**Response to Submissions
Section 96(1A)
Modification Application
(MOD 2)**

Horsley Drive Business Park

Prepared by McKenzie Group Consulting Planning
on behalf of Australand Property Group
May 2015

Horsley Drive Business Park

DRAFT - STAGE 1

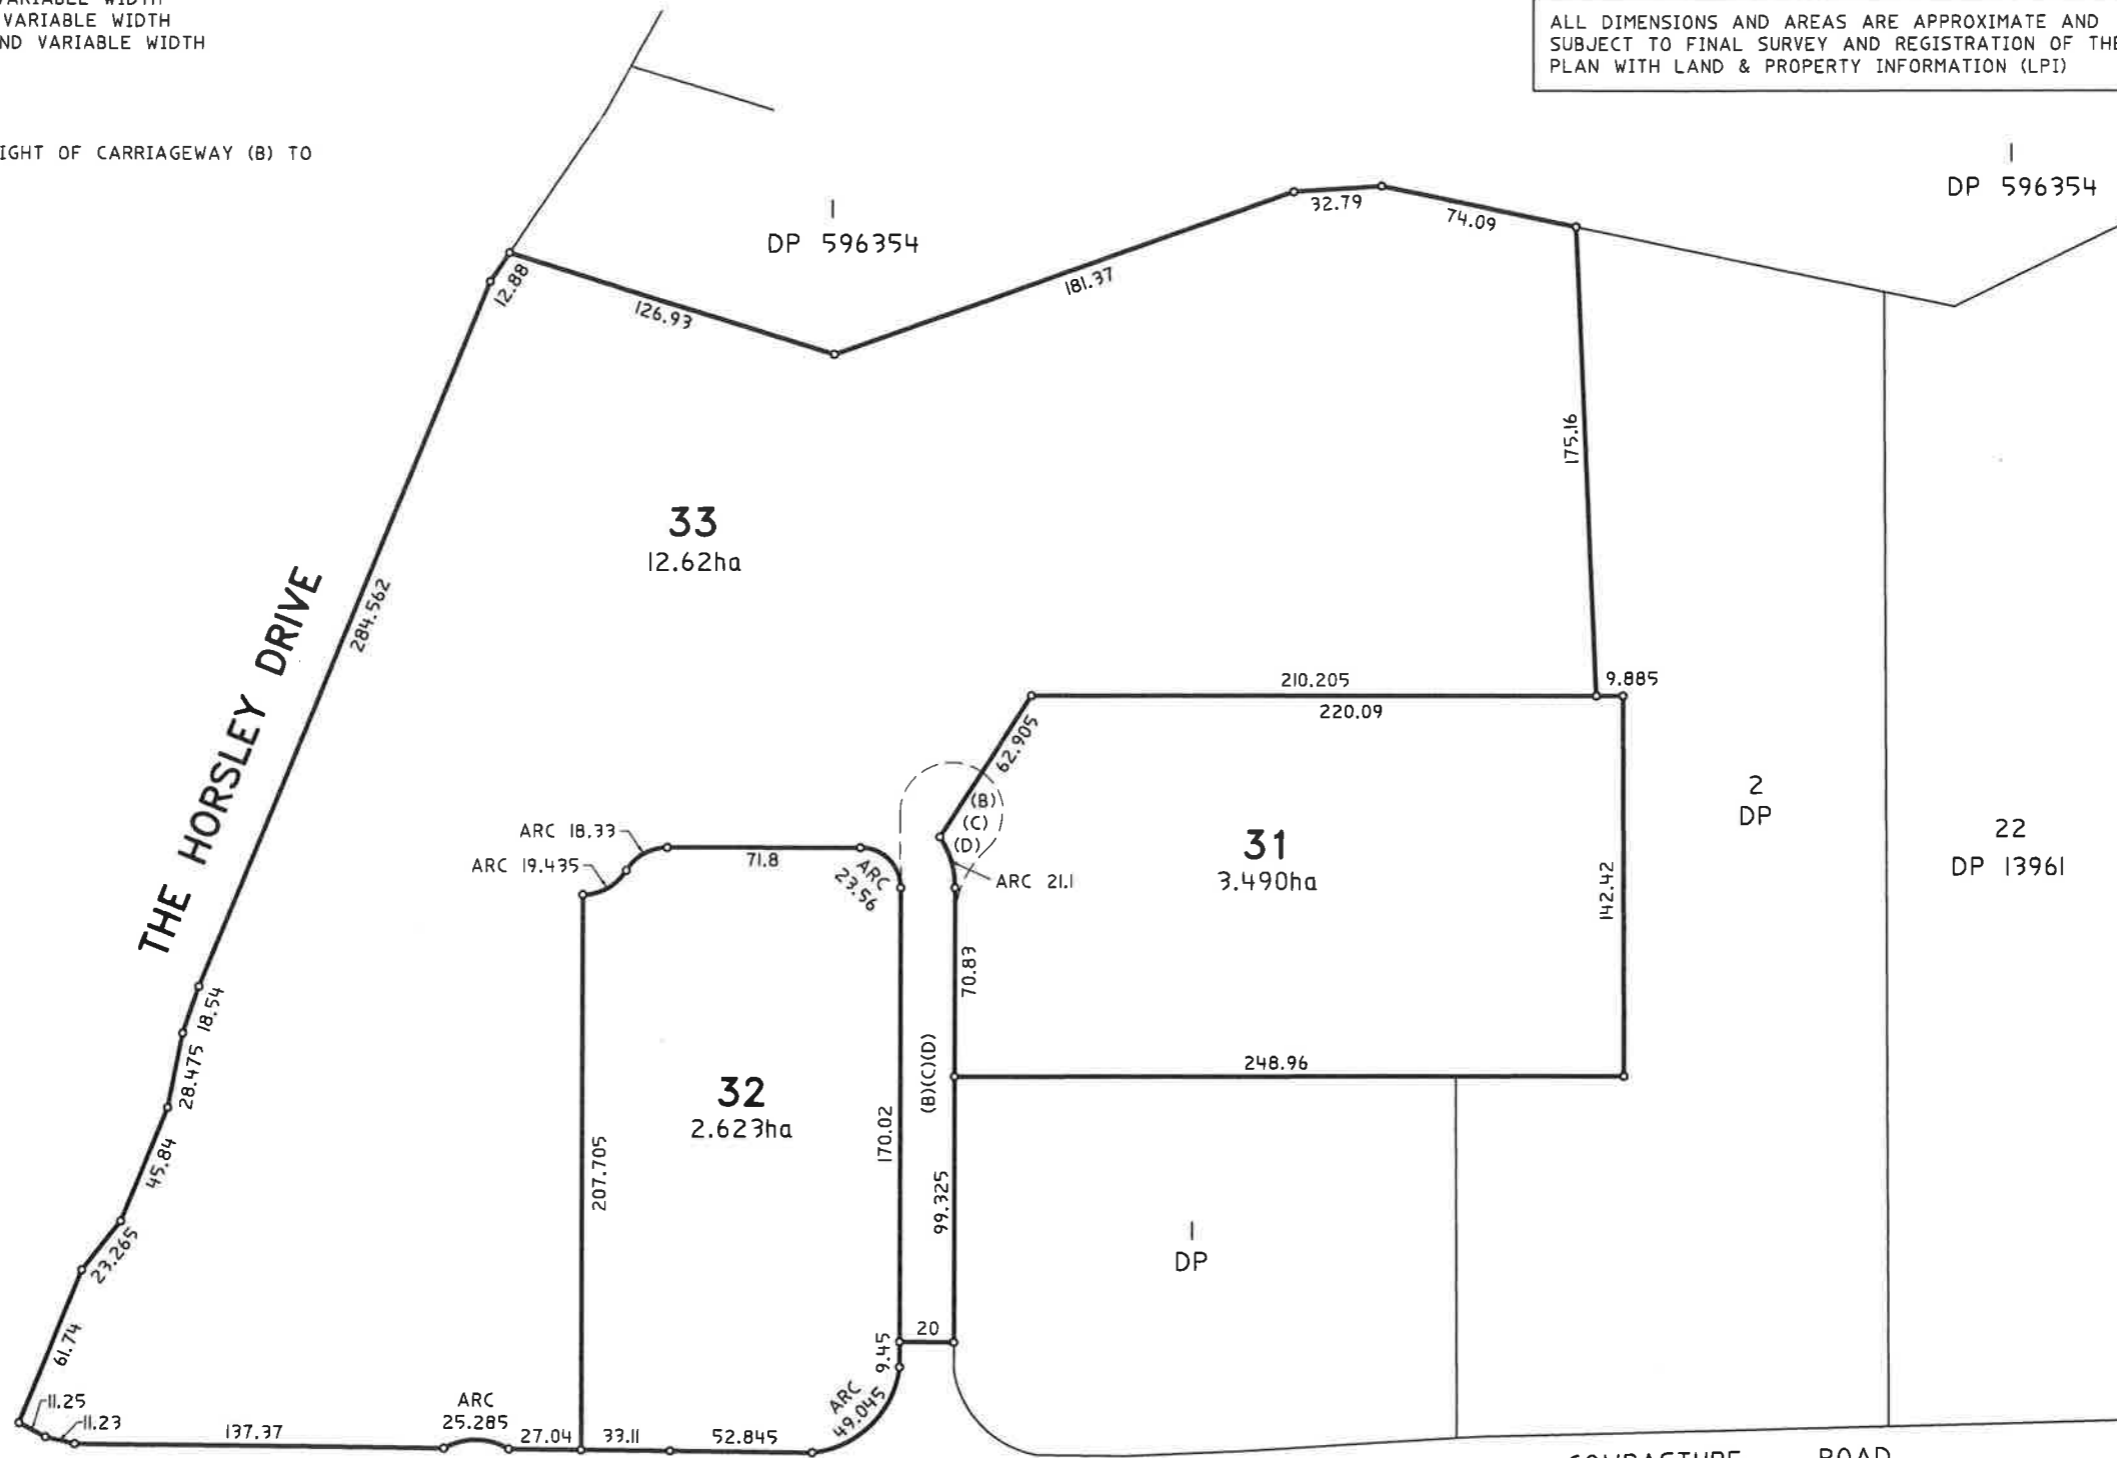
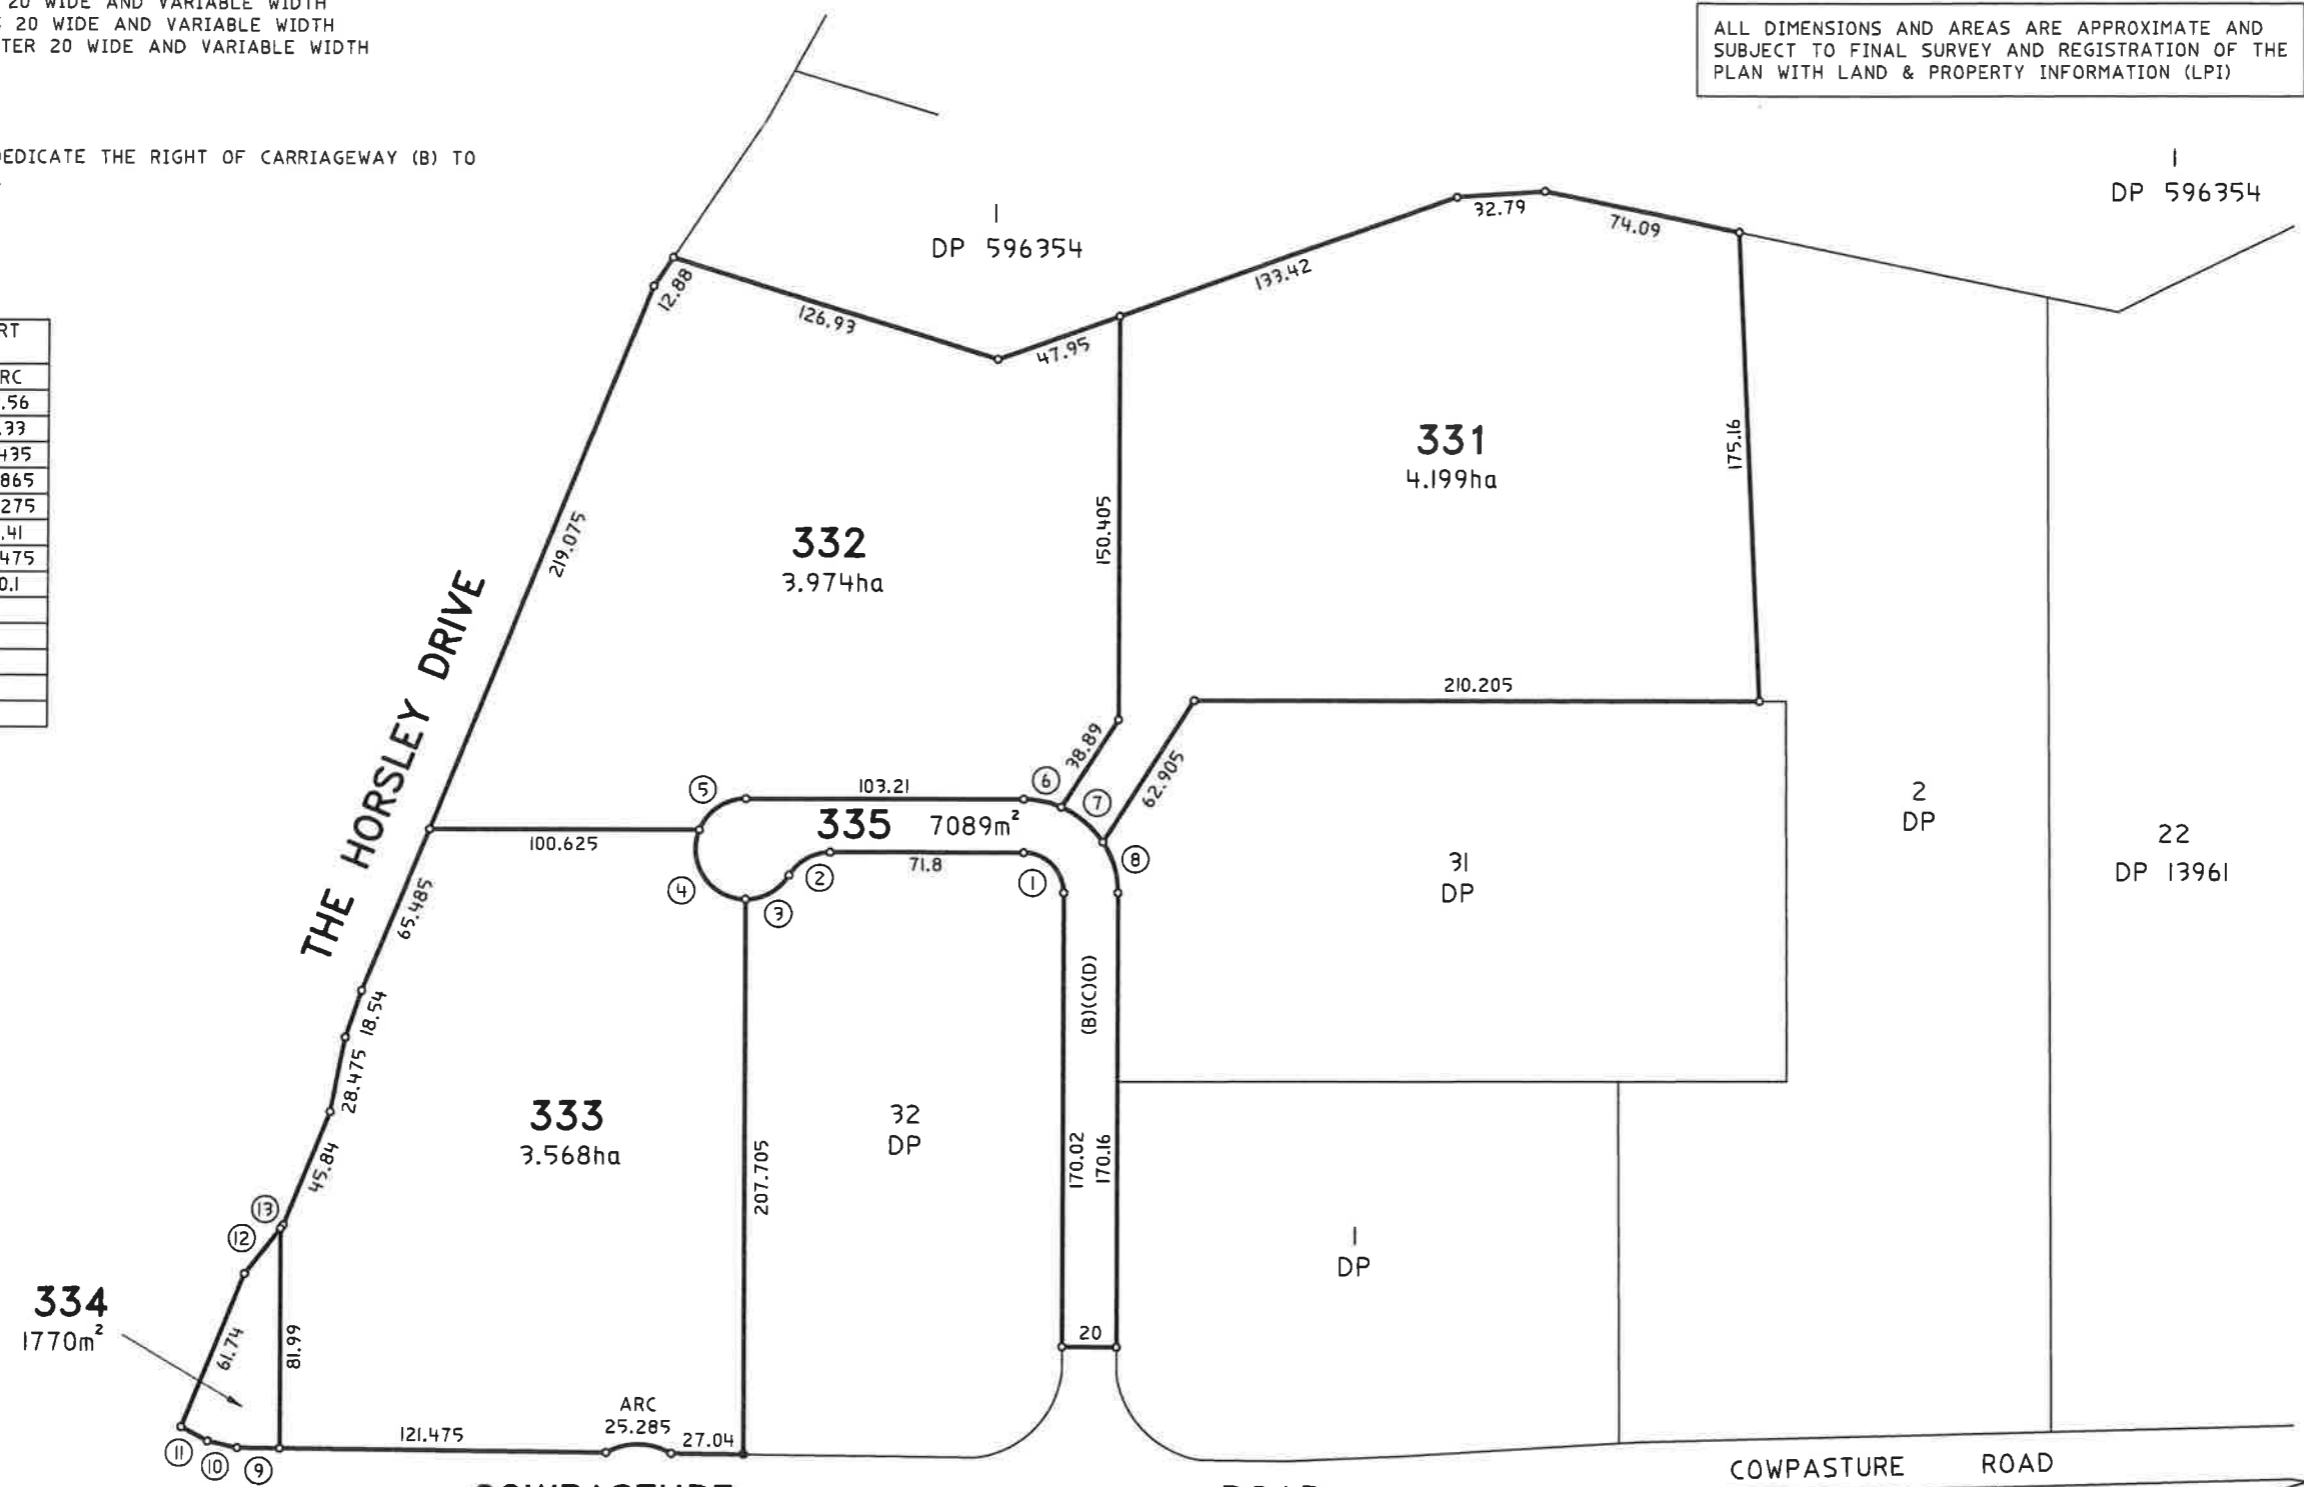
<p>3. Clarification of the Number of Stages</p> <p><i>The development consent provides for three stages. The Staging Plan, which accompanied the modification request dated February 2015, refers to 2 stages. However, the Draft Staged Plan of Subdivision in Appendix 4 of the modification request specifies that four stages are proposed.</i></p>	<p>It is now proposed to delete reference to staging of the Estate on Drawing MP-WSPT-FS-011. A revised Estate Masterplan is annexed to this submission (Appendix 3) which details such. The staging is still required for the Subdivision of the land; however this is not staged development as defined under the Act.</p> <p>For the purpose of issuing a subdivision certificate as a staged approach, the following condition is required.</p>

Table 1 – Submissions and Responses	
NSW Department of Planning & Environment	
Summary of Submission	Response
<p><i>Please clarify the number of stages involved in the proposed modification, together with the intent of proposed Condition D1A.</i></p>	<p><i>D1A. Approval is granted under this consent (SSD 5169 – MOD 1) to carry out subdivision and the works within the estate as a two phase process for each stage of the development:</i></p> <p><i>Phase 1 – Create residue lots and a lot for the road providing easements for services and right of carriageway (over 3 sub-stages).</i></p> <p><i>Phase 2 – Extinguishment the easement for services, right, of carriageway and dedication of the road as "public road" to Fairfield City Council, following the works construction.</i></p>
<p><i>4. Section 96 of the Environmental Planning & Assessment Act 1979</i></p> <p><i>The Department is concerned that the proposed modification would not have a minimal environmental impact as required under Section 96(1A). Please provide justification as to why the Department should assess the as a Section 96 modification Application.</i></p>	<p>As the modifications sought result in the development being substantially the same as that which consent was originally granted for, the provisions under Section 96(1A) of the Act apply. The following tests require consideration in this instance:</p> <p><i>A consent authority may, on application being made by the applicant or any other person entitled to act on a consent granted by the consent authority and subject to and in accordance with the regulations, modify the consent if:</i></p> <p><i>(a) it is satisfied that the proposed modification is of minimal environmental impact</i></p> <p>The proposed development (as amended) shall result in minimal environmental impact on surrounding properties. On balance, the proposal is considered to satisfy this test for the following reasons:</p> <ul style="list-style-type: none"> ▪ Traffic generation rates are generally consistent with that approved under the parent approval being SSD 5169;
